From: Anita Gardner <Anita.Gardner@arun.gov.uk>
Sent: 19 April 2021 10:26
To: Planning.Responses <Planning.Responses@arun.gov.uk>
Subject: FW: LU/62/21/L - 13 South Terrace, Littlehampton

From: Kim Anderson [REDACTED]
Sent: 19 April 2021 10:00
To: Ross Anderson [REDACTED] Anita Gardner <Anita.Gardner@arun.gov.uk>
Subject: Re: LU/62/21/L - 13 South Terrace, Littlehampton

From: Anita Gardner <Anita.Gardner@arun.gov.uk>
Subject: LU/62/21/L - 13 South Terrace, Littlehampton
Date: 15 April 2021 at 16:26:11 BST

13 South Terrace Floor 2

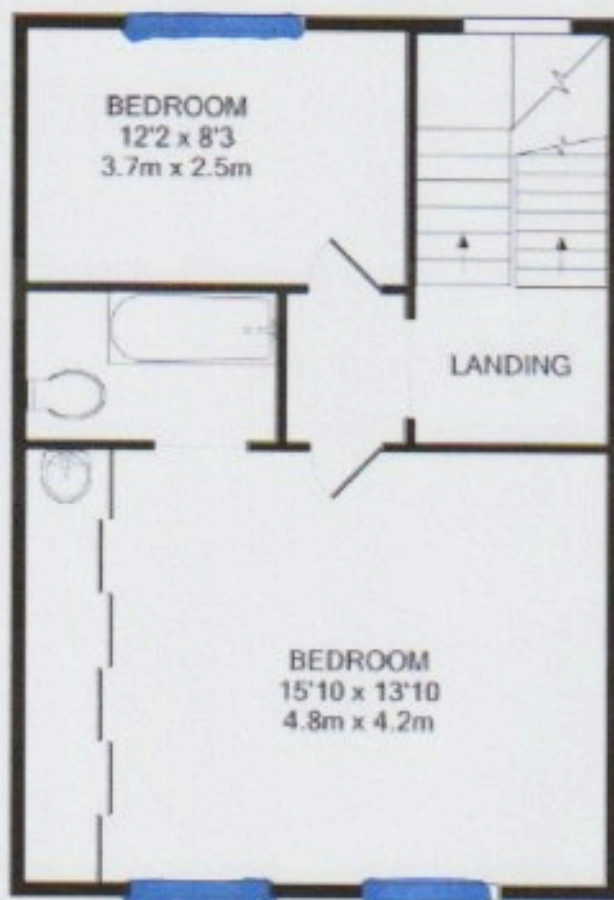
Likewise, it is not clear what the replacement windows will look like, and I am concerned with references to the presence of double glazing (this would have required consent). Further details of the proposed replacement windows are required.

There are two windows at the front of the house on the top floor that are currently double glazed UPVC casement windows. They are defective and need replacing. There are no records of planning consent having been obtained to install these windows and we would like to replace them with timber casement windows which are sympathetic with the period of the building and style of the existing original windows. Are we allowed to have double glazed glass in the timber windows for energy efficiency or will they have to be single glazed? We will be using a local company who have completed approved window works in South Terrace recently and they can submit exact details if required.

13 South Terrace Floor 1

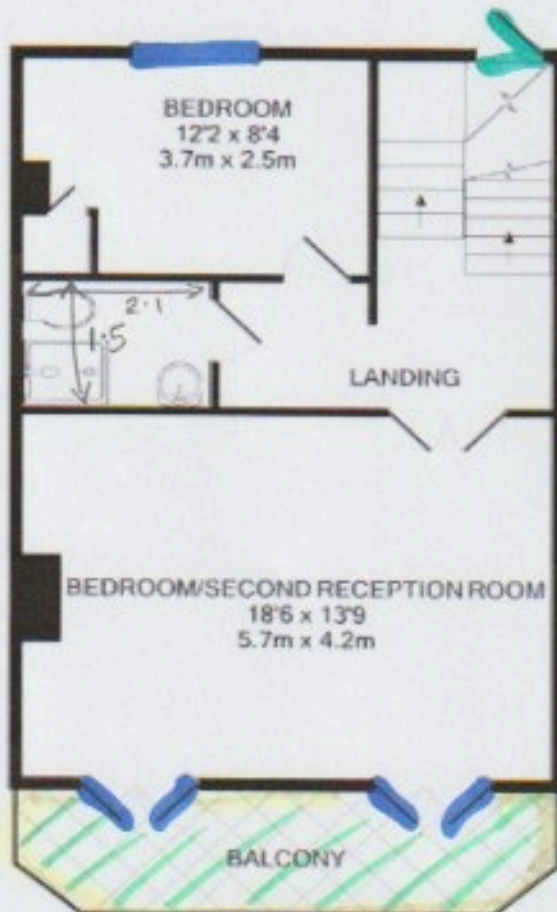
The works to the balcony indicate that the felt covered canopy needs replacing and the structure of the balcony needs refurbishing/repainting. However, it is not clear what materials will be used on the roof or what kind of works are required to refurbish the balcony. For instance, will the railings be replaced, and if so, what with? Also, will the paint colour remain the same or change? If it will change, what colour is proposed?

The felt covered canopy will be replaced with like for like existing materials ie same colour, texture, appearance. We do not intend replacing the existing woodwork of the balcony with any other material apart from similar wood and the balcony will be painted white as it is currently. We don't want to replace any of the wooden structure unless it is considered unrepairable and/or unsafe in which instance we would use the same materials and the facade will not be altered.
